Item No. **Report of the Head of Planning, Sport and Green Spaces**

Address 2 WITNEY CLOSE ICKENHAM

Development: Part two storey, part single storey rear extension

LBH Ref Nos: **15267/APP/2016/118**

PROPOSED GROUND FLOOR PLAN 1:100

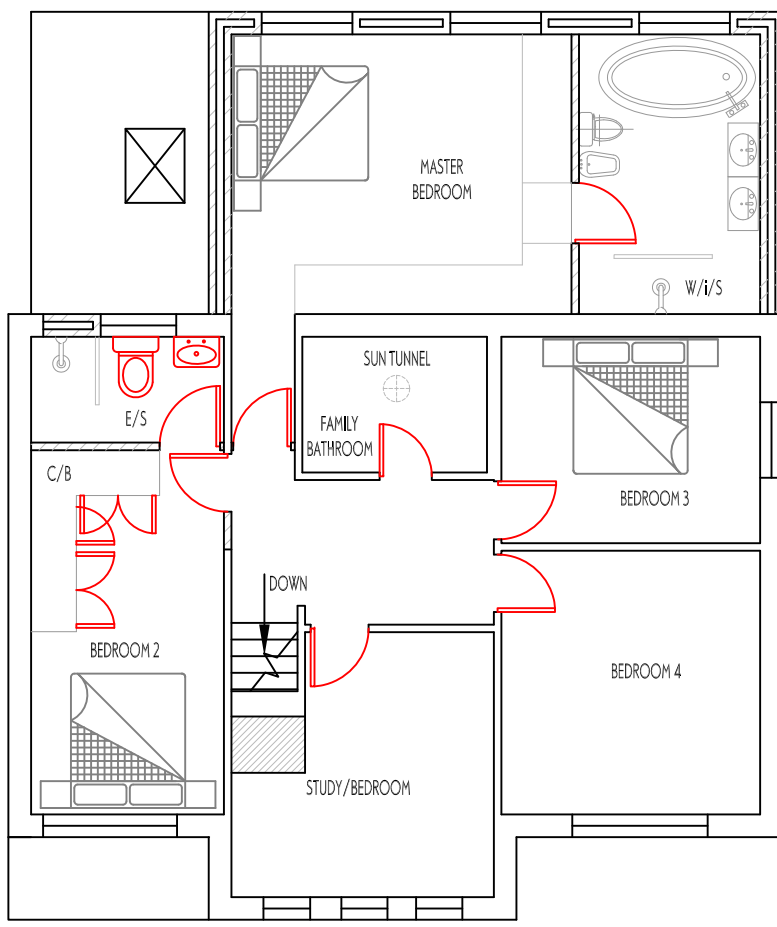
The plans show that the existing conservatory will be demolished in order to make way for the proposed rear extension.

The proposed single storey rear extension will have a depth of 4m and will be 9.96m wide, as it will extend the entire width of the dwelling. The single storey rear extension will consist of a pitched roof which will be approximately 3.76m in height. Although this exceeds the 3.4m as stated in the HDAS, an exception can be made for this case, as the proposed increase in height will not obstruct any neighbouring occupier's light or outlook. Furthermore it appears that the single storey rear extension at no.1 Witney Close is of similar height to the proposed single rear extension.

The first floor of the rear extension will not extend beyond a 45-degree angle, ensuring no over dominance, overshadowing or loss of outlook. The proposed first floor rear extension will have a depth of 4m and will be approximately 7.64m wide, as it will be set in from the side of the dwelling by approximately 2.36m. This set in further ensures that the proposed extension will not breach the 45-degree line of sight.

The roof of the first floor rear extension will consist of a gable roof, which will be set down from the ridge of the main dwelling by approximately 0.50m.

Plans show that the existing garage will be converted into bedroom.

The side elevation of the original dwelling, facing the side boundary shared with no.3 Witney Close, will consist of 2 windows on ground floor level and a new window at first

floor level. The windows on ground floor level will serve the 'formal room' while the window at first floor level will serve Bedroom 3. Although these windows will be fully glazed, they are not considered to result in any overlooking into no.3 Witney Close. The ground floor windows will be facing the shared side boundary, while the first floor window will be set away from any habitable room windows at no.3. The 2 side doors will be situated on the side elevation of the proposed ground floor rear extension, and as result will also be facing the shared side boundary.

PROPOSED FRONT ELEVATION 1:100

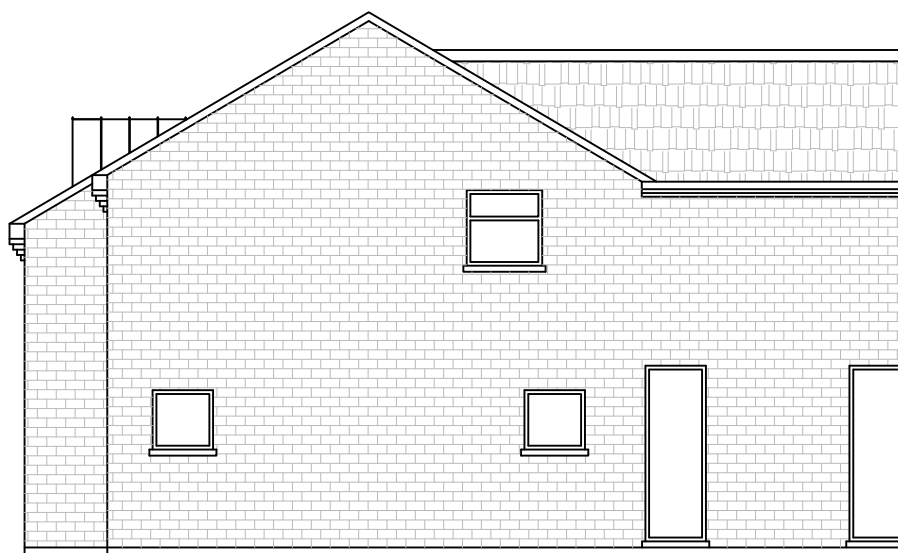
The front elevation of the property currently consists of brick, while the right hand side of the front elevation consists of white render. The plans show that the left hand side, which is currently brick, will also be rendered to match the existing, leaving the middle section bricked. This is not considered to have a detrimental impact upon the street scene, as no.1 Witney Close is almost similar to what is being proposed. Also no .5 is all rendered, which means that the front alterations will complement the remaining properties on Witney Close.

The proposed rear extension will have windows and doors located on its front and rear elevations.

The proposal will also include windows and doors on the side elevation of the proposed extension, as well as the side elevation of the original dwelling.

Notwithstanding the provisions of the Town and Country Planning (General Permitted Development) Order 2015 (or any order revoking and re-enacting that Order with or without modification), no additional windows, doors or other openings shall be constructed in the walls or roof slopes of the development hereby approved facing no.3 Witney Close.
